**Submission on proposal (SSD 7311), Research and Education Facility – Taronga
Institute of Science & Learning at Taronga Zoo, Bradleys Head Road, Mosman**

Rajeev Maini
A/Manager Conservation
Heritage Division
Office of Environment and Heritage
As Delegate of the NSW Heritage Council
4 March 2016

**Figure 2.35** View of remnant section of stone wall within site. Source: Kristine Marshall

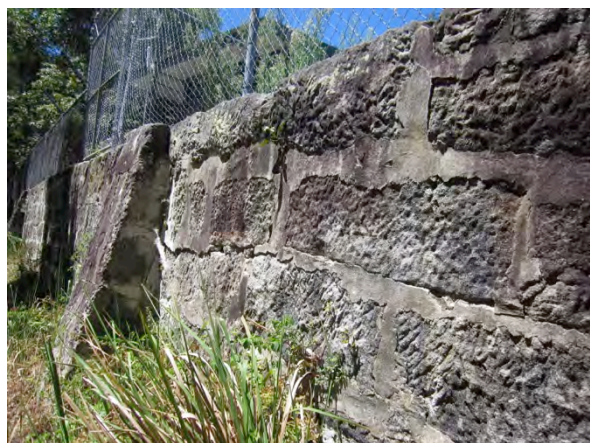
- The section of remnant stone boundary wall shall be retained, expressed and conserved as part of the subject landscape works. Detailed documents must show this remnant wall in relation to the off holding aviaries. Conservation works and methods should be part of the detailed documentation including lime-based mortar repointing. The sandstone previously demolished from this wall and now incorporated in garden beds should be salvaged and reused.
